CITY OF ALBUQUERQUE

March 5, 2019

Re: Aloha RV
8212 Pan American FWY
Traffic Circulation Layout
Engineer's/Architect's Stamp **02-26-19** (C18D104)

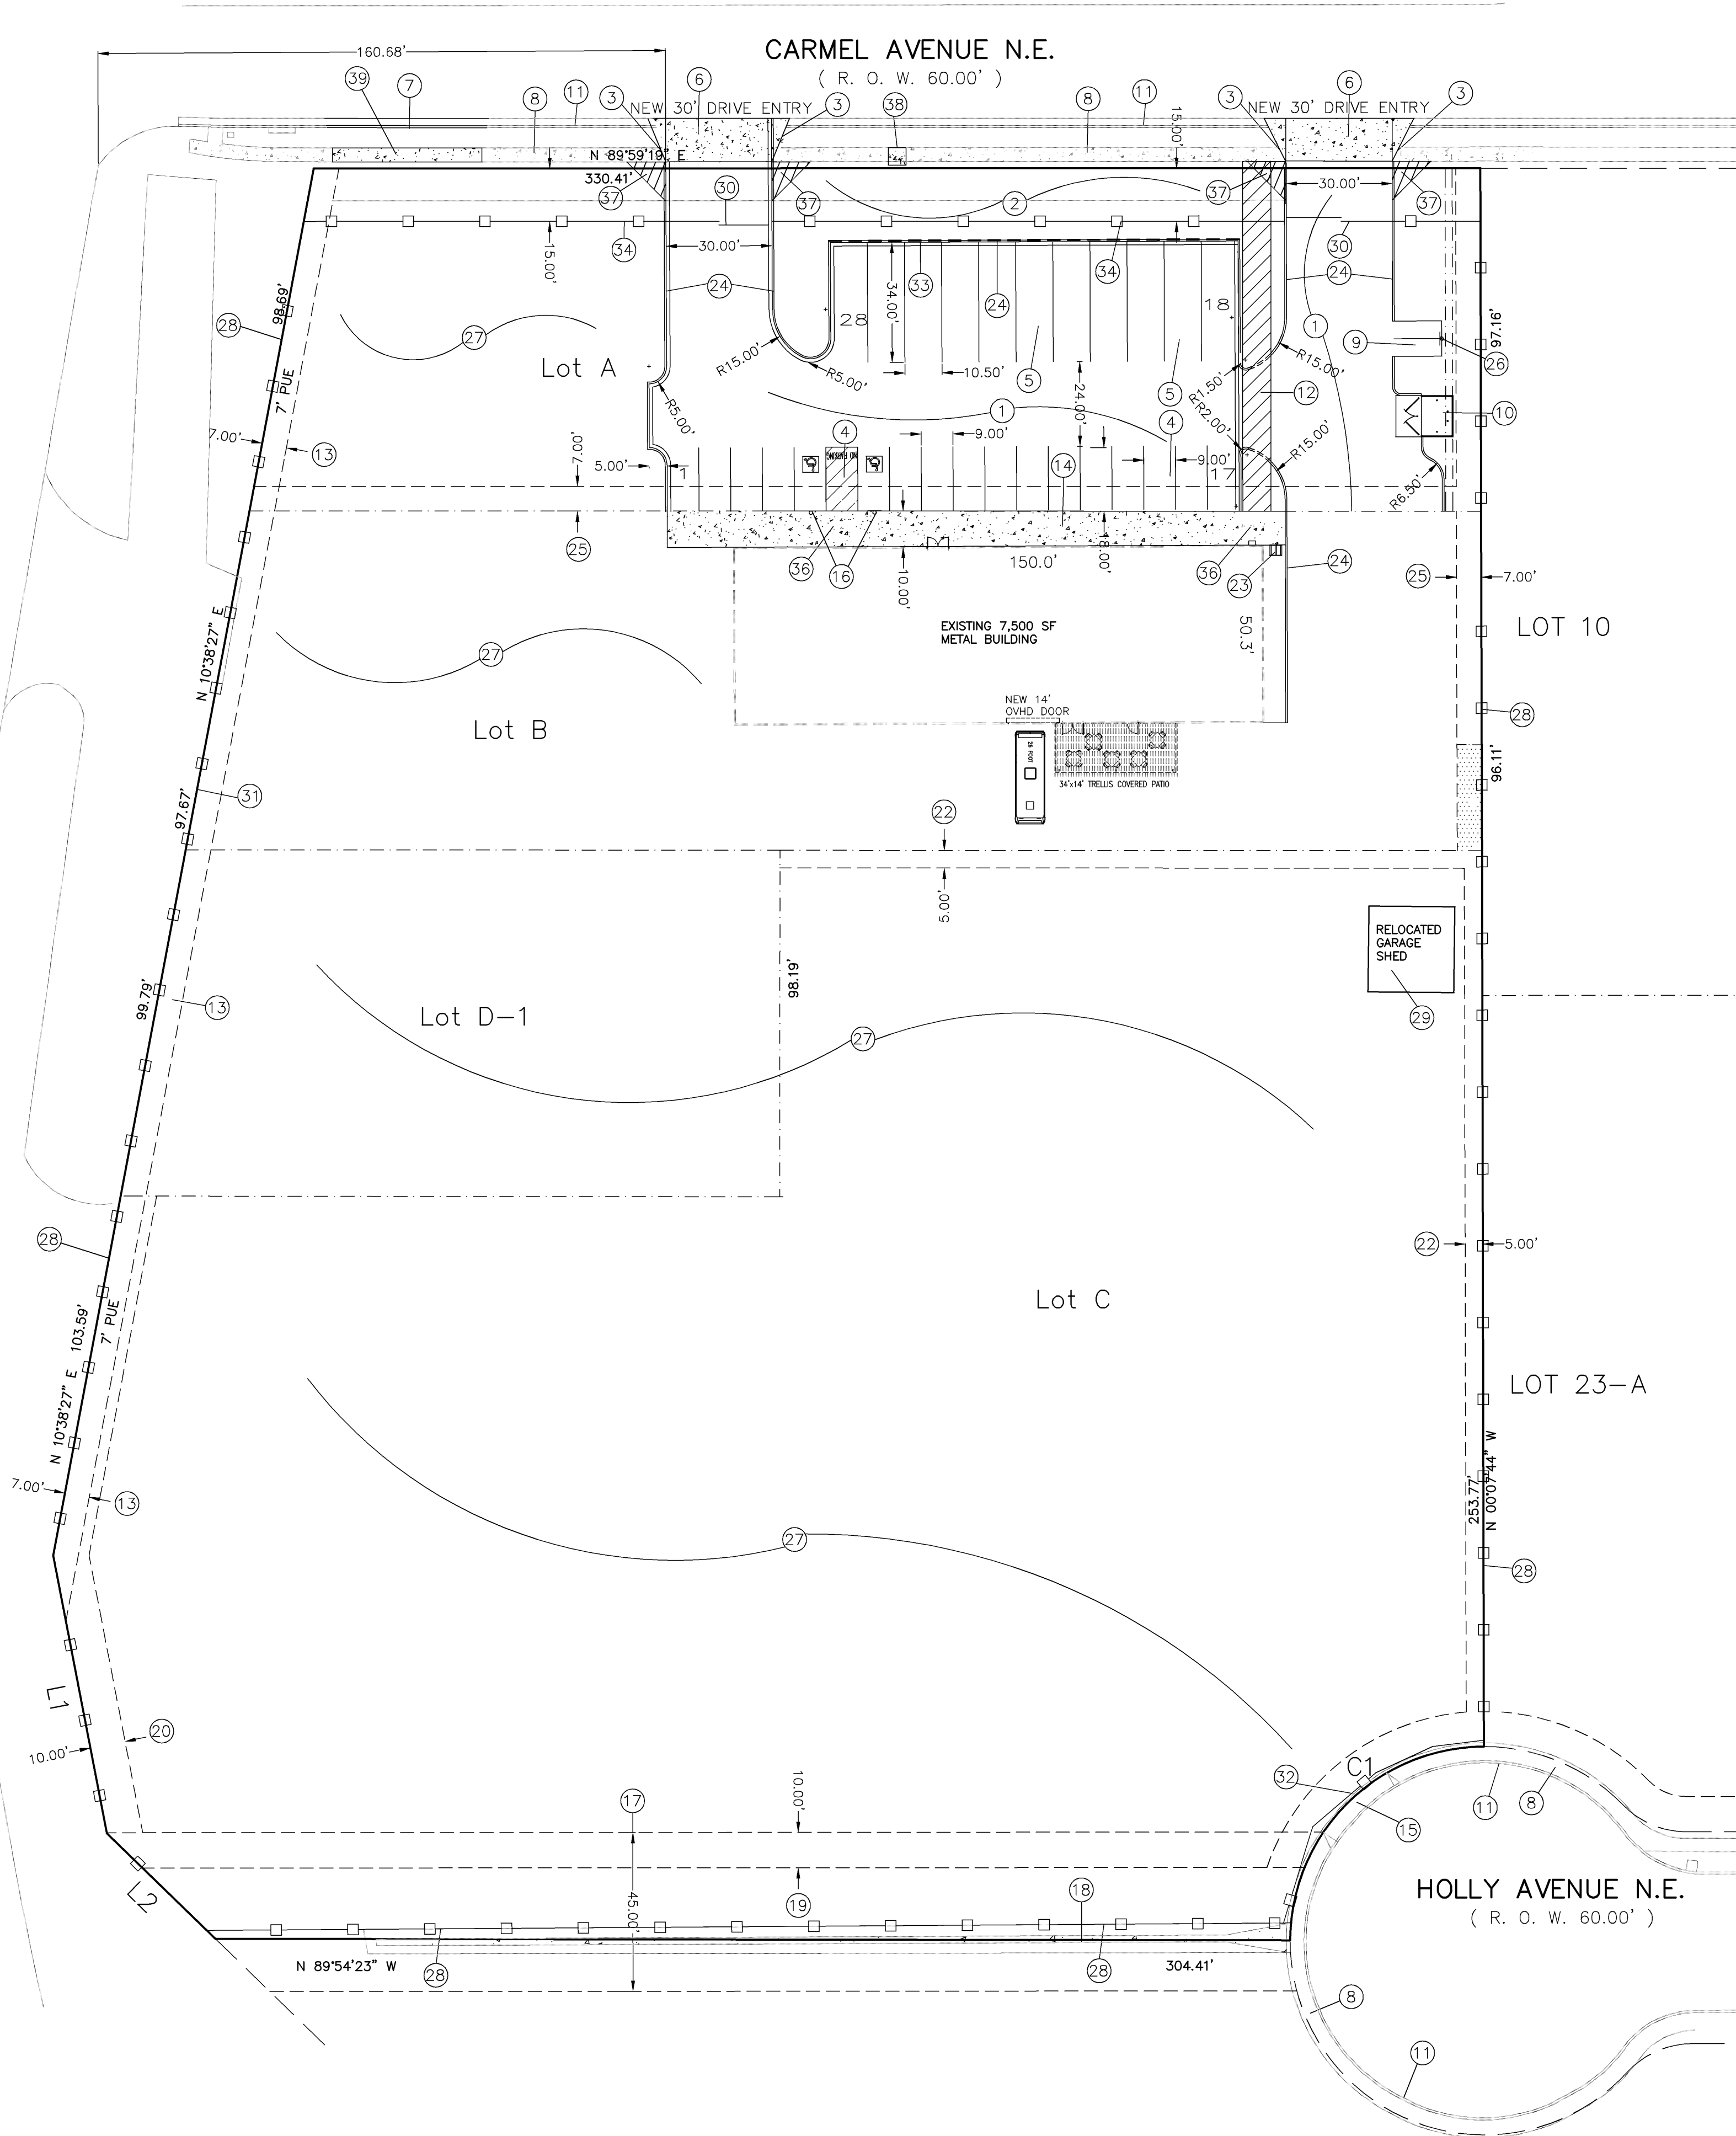
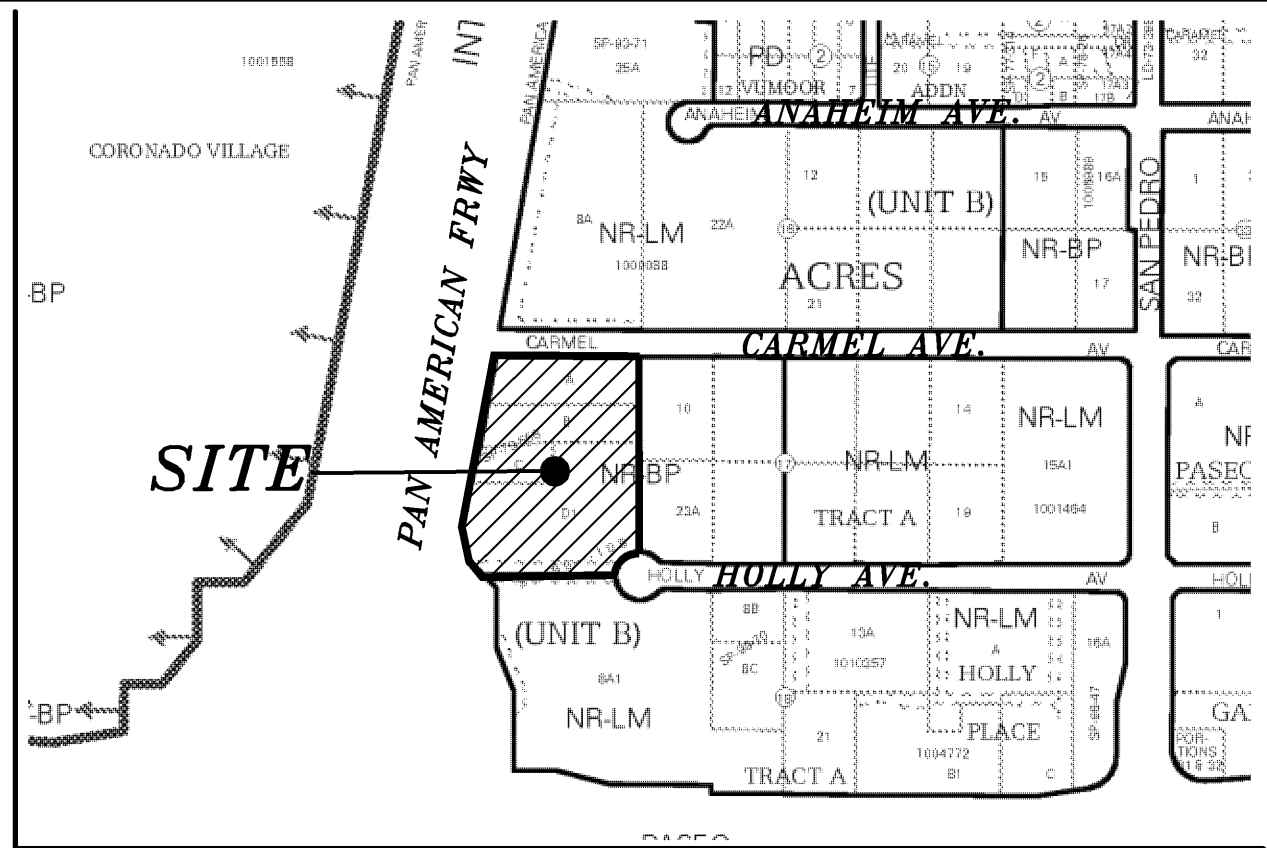
2. The new access on Carmel street is close to I-25 and needs to be checked with Nancy at NM-DOT.
3. Since this site has different lots, a cross access easement is needed. Also, the parking spaces can not cross over the lot lines. Please consider adjusting the parking spaces.

4. The ADA access aisles shall have the words **"NO PARKING"** in capital letters, each of which shall be at least one foot high and at least two inches wide, placed at the rear of the parking space so as to be close to where an adjacent vehicle's rear tire would be placed. (66-1-4.1.B NMSA 1978)

5. ADA curb ramps must be updated to current standards and have truncated domes installed.
6. List radii for all curves shown; for passenger vehicles, the minimum end island radius for passenger vehicles is 15 ft. Radius for delivery trucks, fire trucks, etc. is 25 ft. or larger.

7. Per the zoning code, a 6 ft. wide ADA accessible pedestrian pathway is required from the public sidewalk to the building entrances. Please clearly show this pathway and **provide details**.

8. Show the clear sight triangle and add the following note to the plan: "Landscaping and signage will not interfere with clear sight requirements. Therefore, signs, walls, trees, and shrubbery between 3 and 8 feet tall (as measured from the gutter pan) will not be acceptable in the clear sight triangle."

9. The keyed note #24 is pointing at bicycle rack, while #23 is a bicycle rack. Please fix that.
